**From:** ENVU Biodiversity and Land Use  
**Sent:** 25 May 2026 17:42  
**To:** Planning ContactCentre  
**Subject:** RE: Attached letter from Kirklees Council regarding application number 2026/91103 at location Dry Hill Farm, Dry Hill Lane, Denby Dale, Huddersfield, HD8 8YN

Please see ecological commentary below:

**Pre-Development Plan  
Baseline Map**

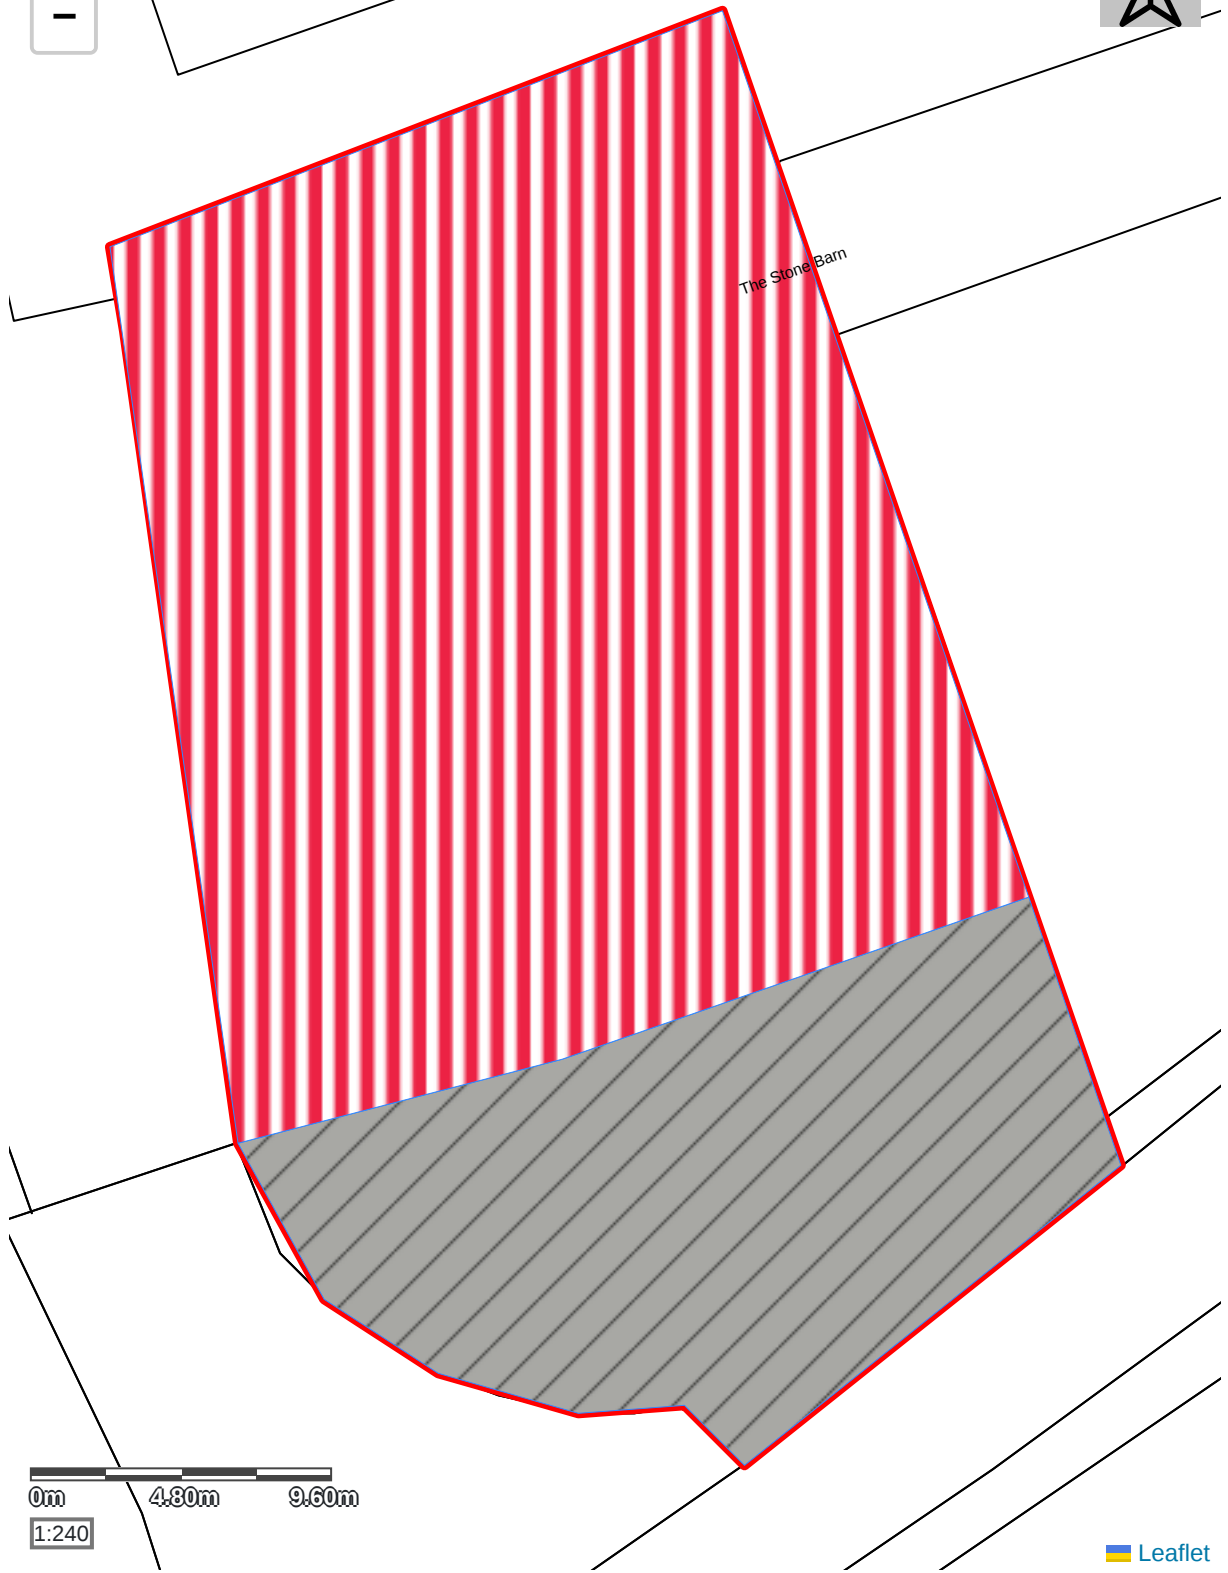
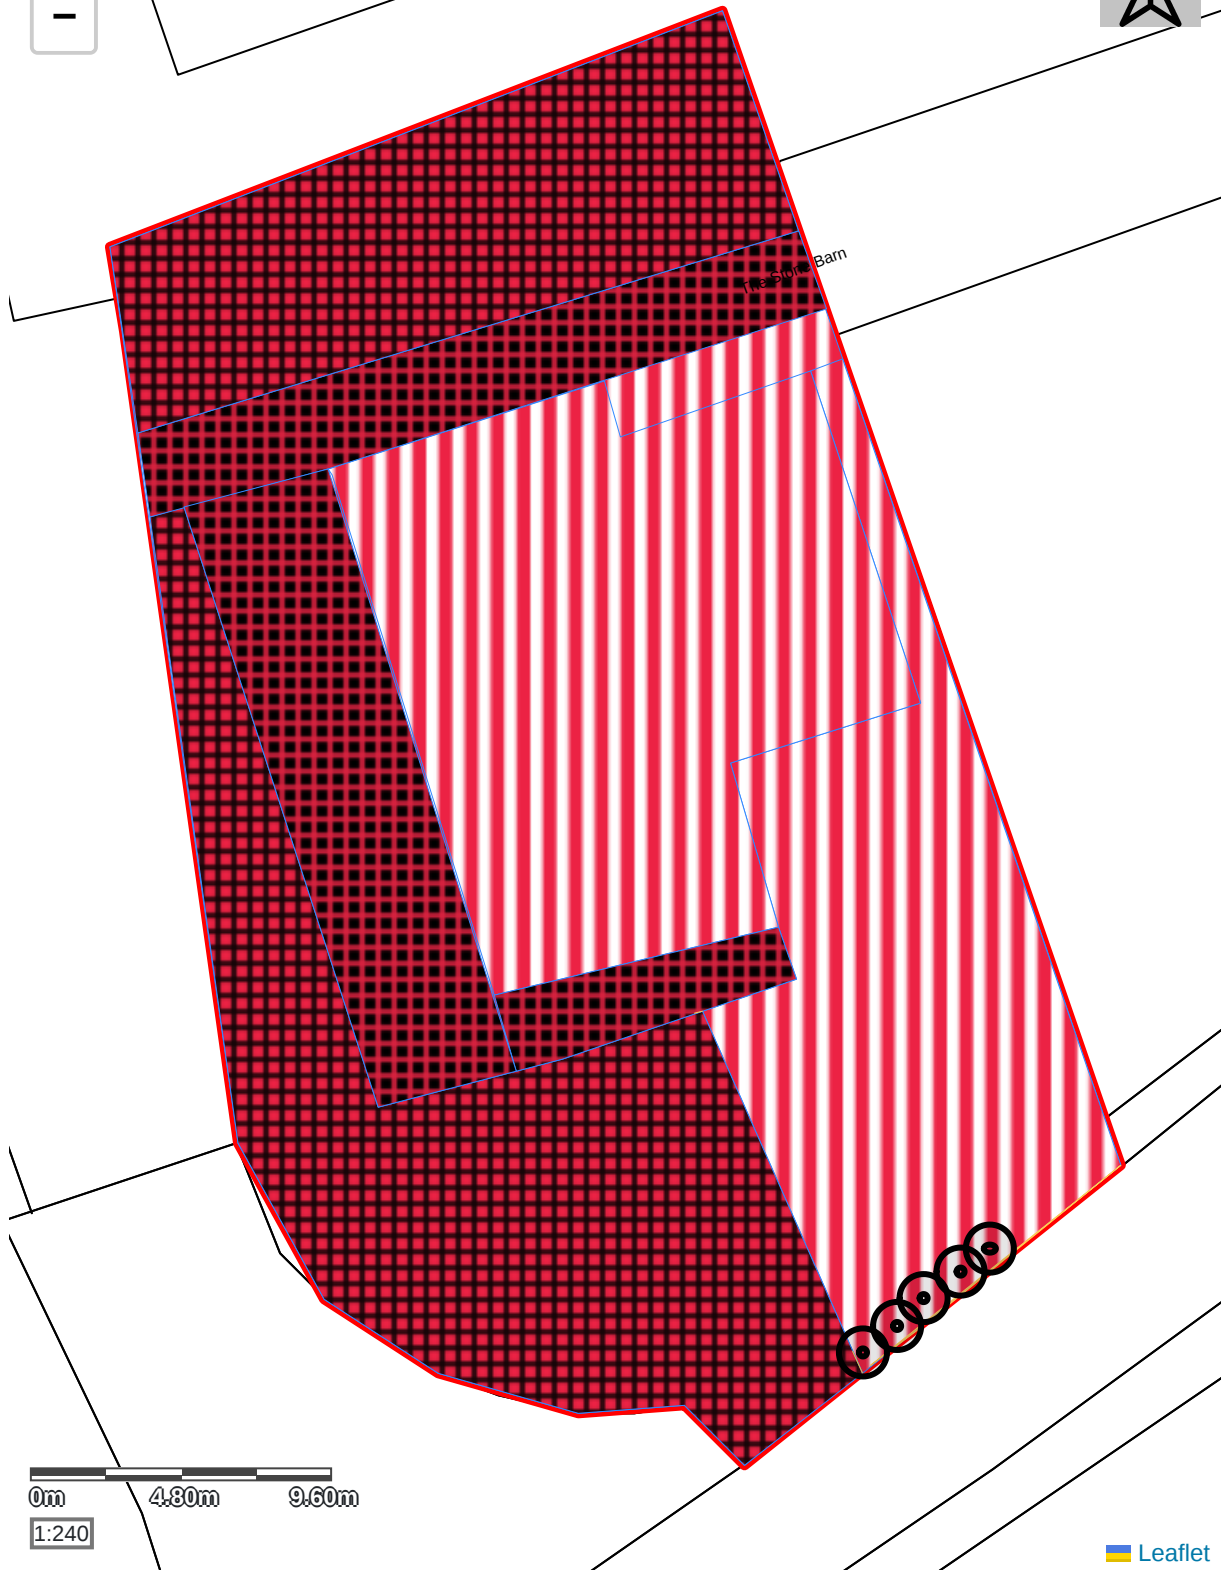
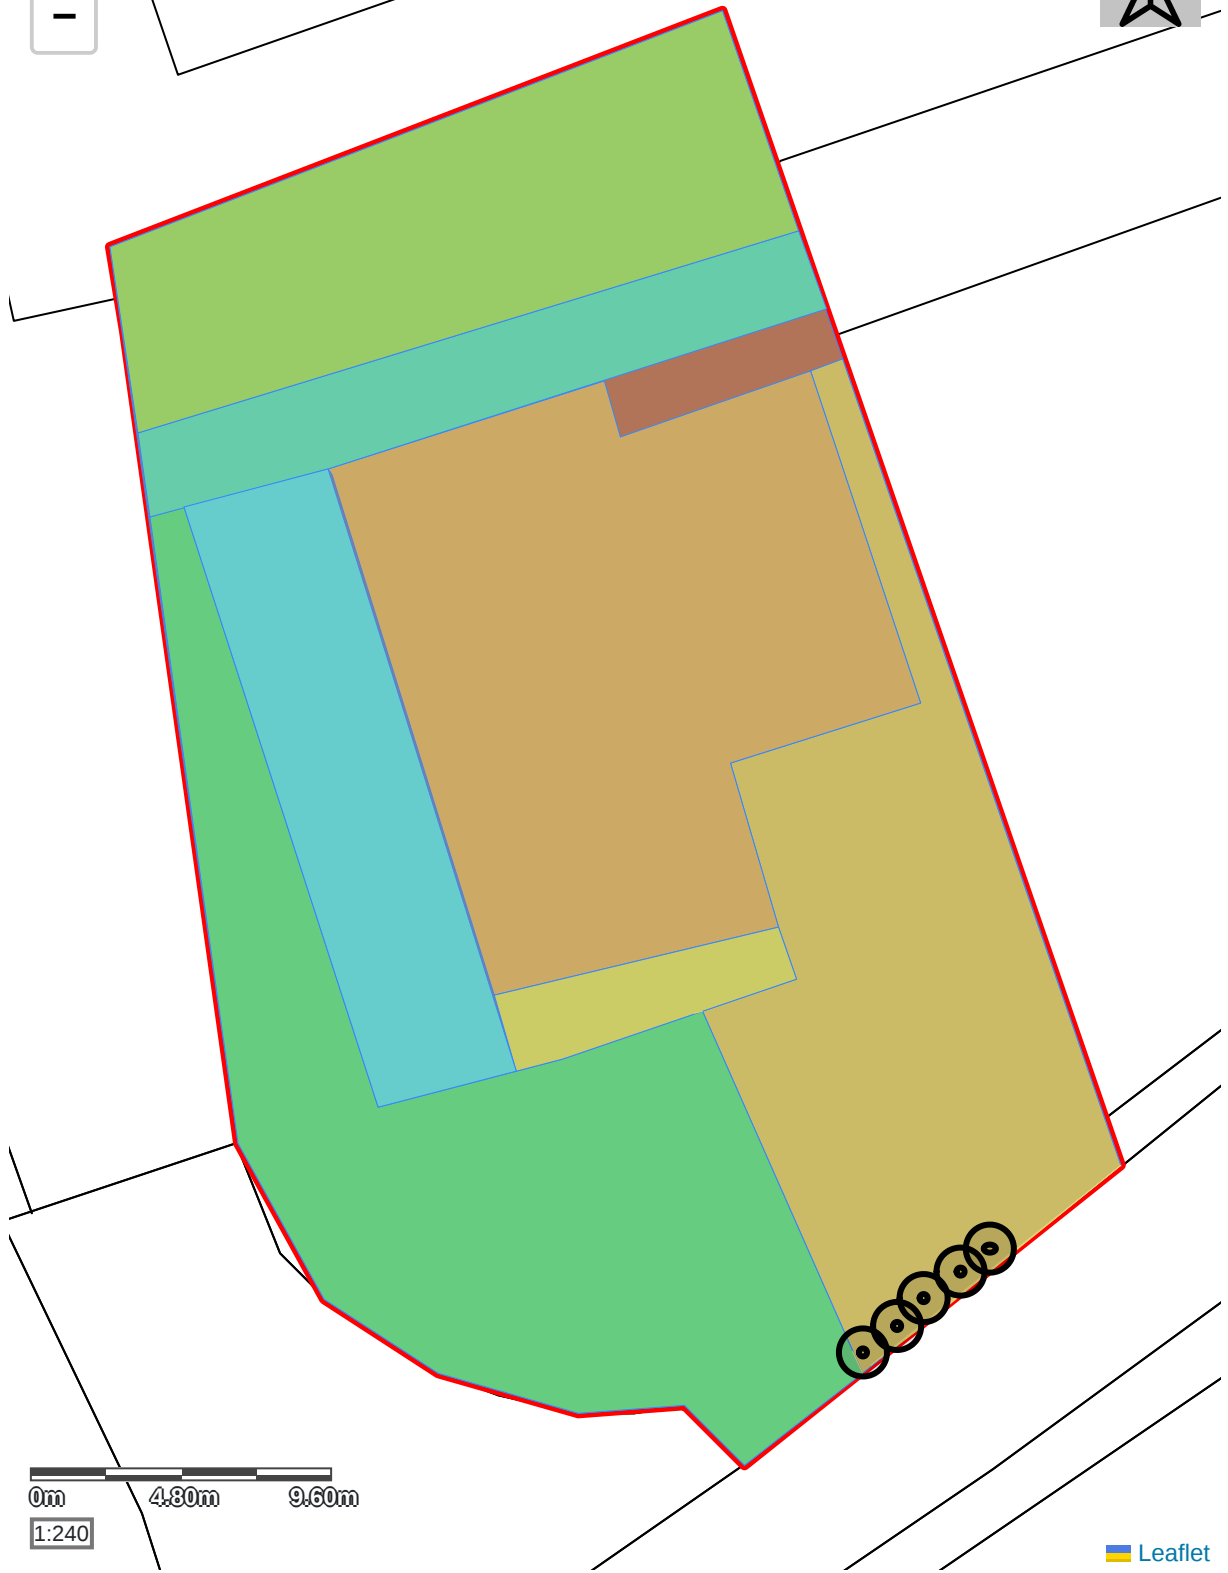
The BNG metric cannot be accepted as:

- We do not understand the qualifications of the person who completed the metric and if they are suitable to recognise the habitats onsite.
- Not all habitats onsite are accounted for
- The walkover survey was completed in September 2024, which makes the assessment out of date.
